PROJECT TITLE: Mountain Mahogany Community School ZONE MAP/DRG. FILE # F-14 / D062
DRB#: _____ EPC#: _____ WORK ORDER#: _____

DATE: 7 February 2012
JOB NO: 1903

REFERENCE: Mountain Mahogany Community School

Mr. Biazar, In response to your review comments dated January 27, 2012, I have made the following revisions to the plan:

PERCOLATION PIT
N.T.S.

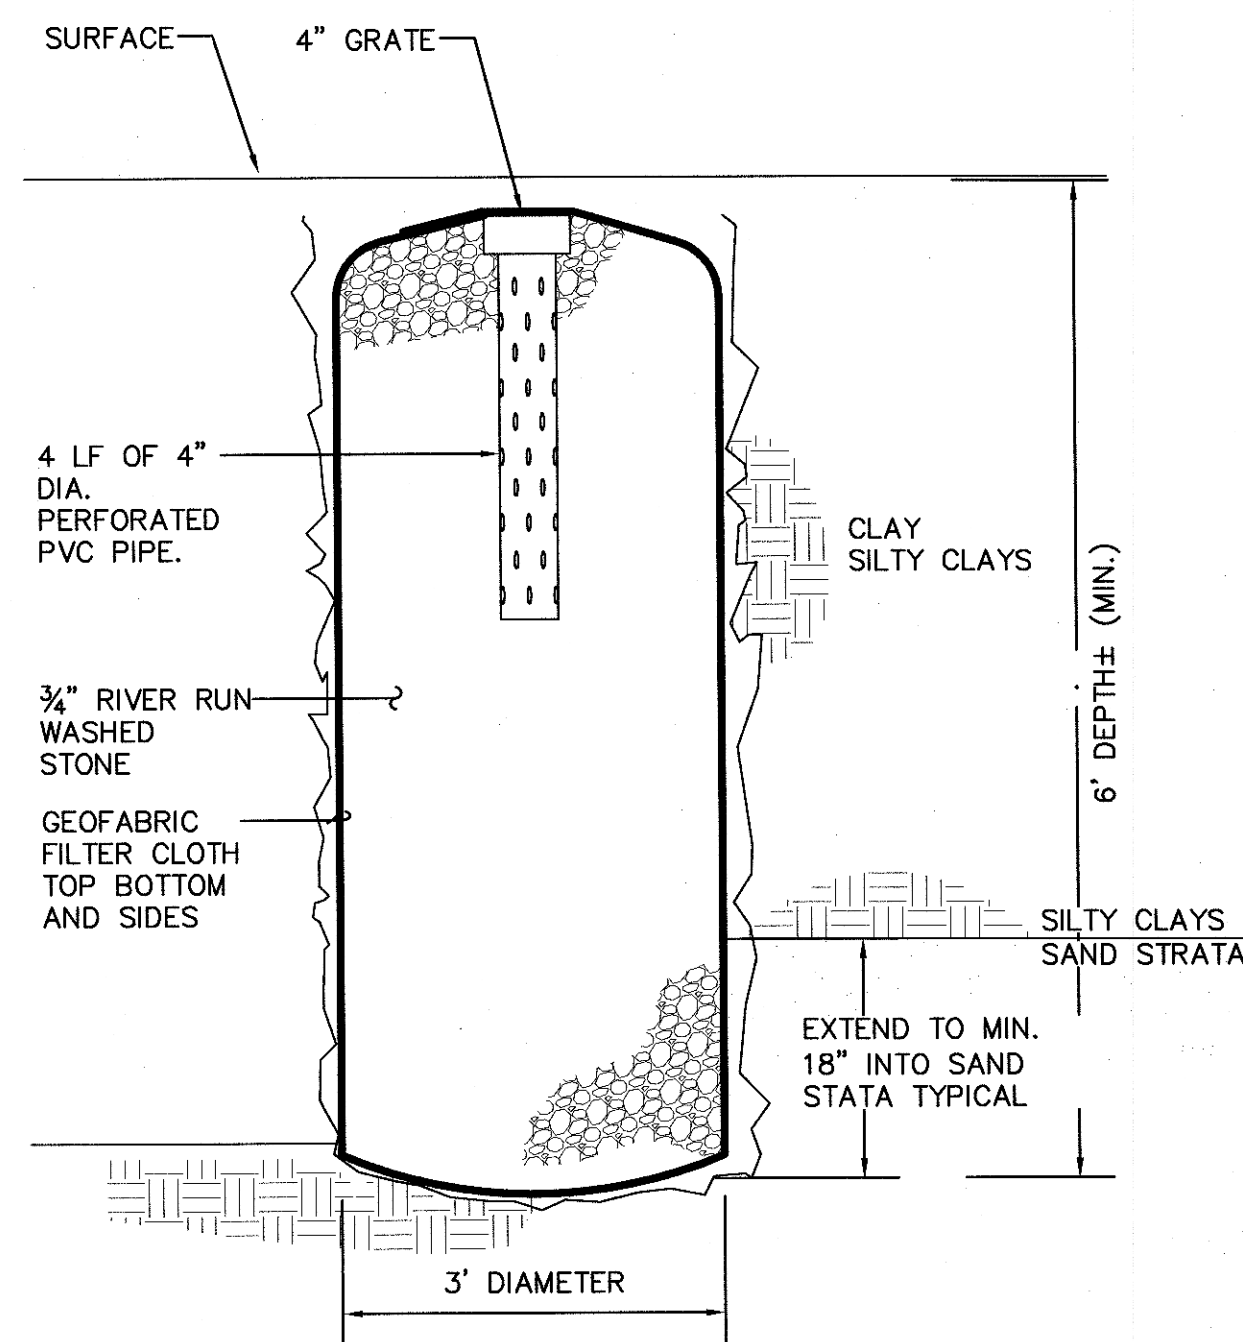
1. A pond volume analysis is included in the supplemental information to address the proposed construction as well as to provide for some additional future improvements.
2. We have called for the installation of six percolation pits within the various ponds to assist with draining the ponds. There is a shallow clay lens (within the upper 4 feet).
